Ribble Valley Borough Council  
Housing & Development Control

Your ref 3/2022/0244  
Our ref D3.2022.0244  
Date 8<sup>th</sup> April 2022

Application no: **3/2022/0244**

Address: **17 Spa Garth Clitheroe BB7 1JD**

Ground Floor/  
Site Plan

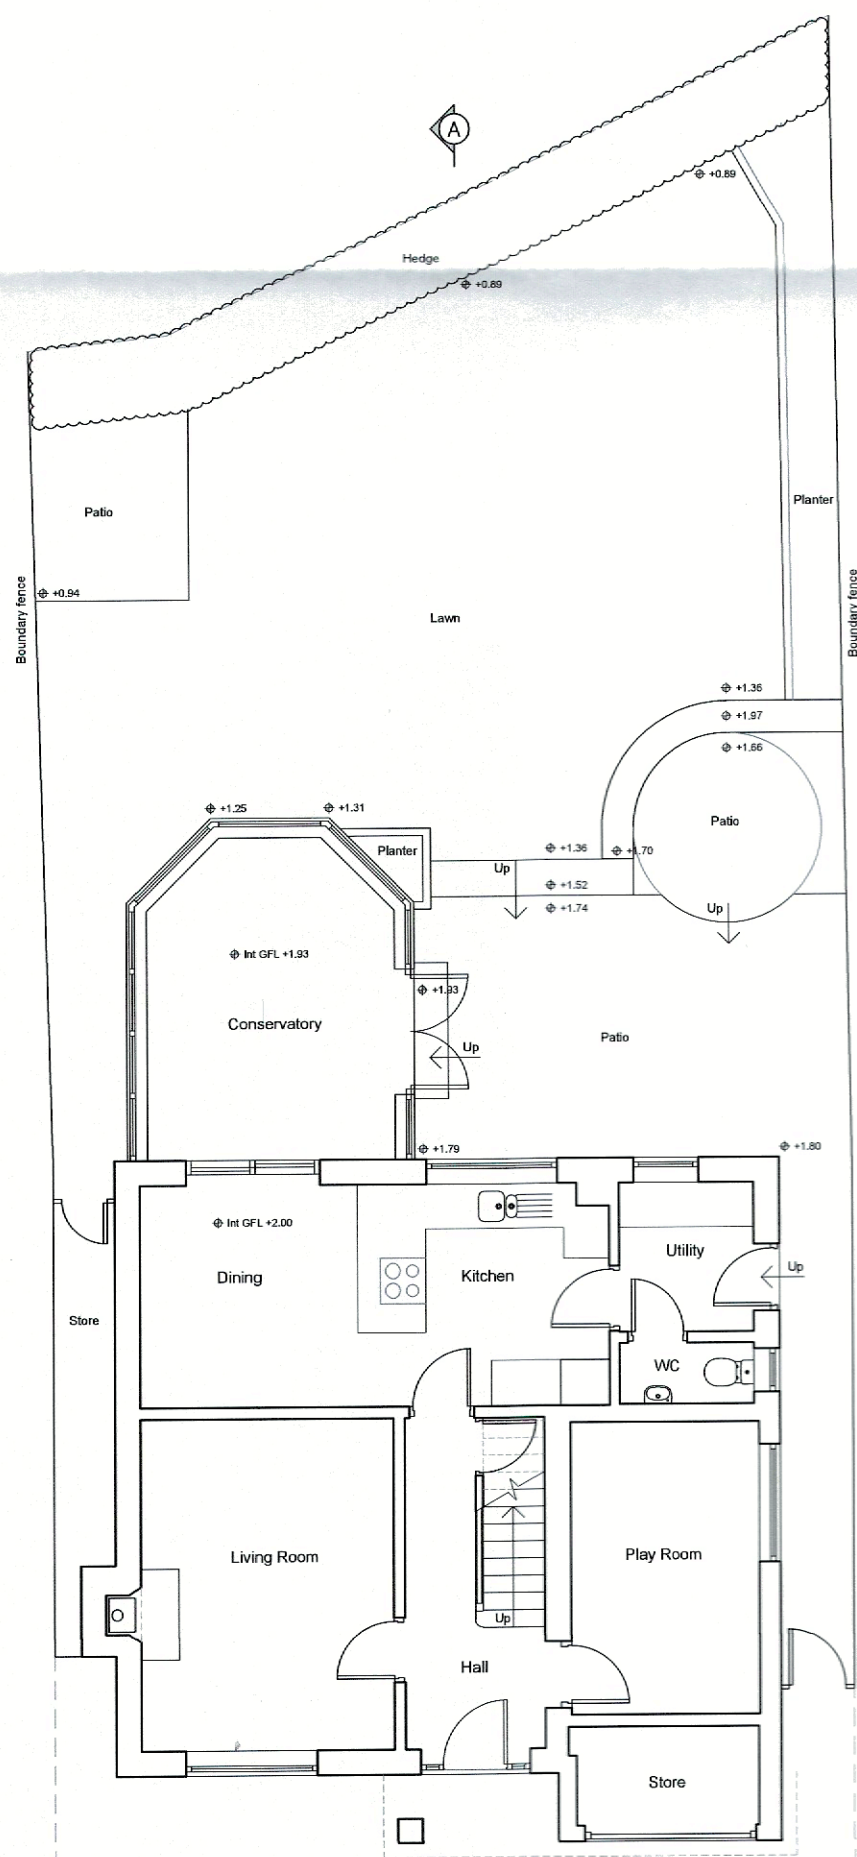
For the proposal to comply with the parking guidance as defined in the Joint Lancashire Structure Plan, the LHA require 3 car parking spaces to be provided on the driveway.

However, the LHA are concerned that only 2 car parking spaces can be provided. The LHA are concerned that a shortfall of one car parking space at the site might lead to on-street parking occurring in the turning head which serves the cul-de-sac. This would be unacceptable and so 3 spaces should be provided at the site, which should be shown on a revised plan.
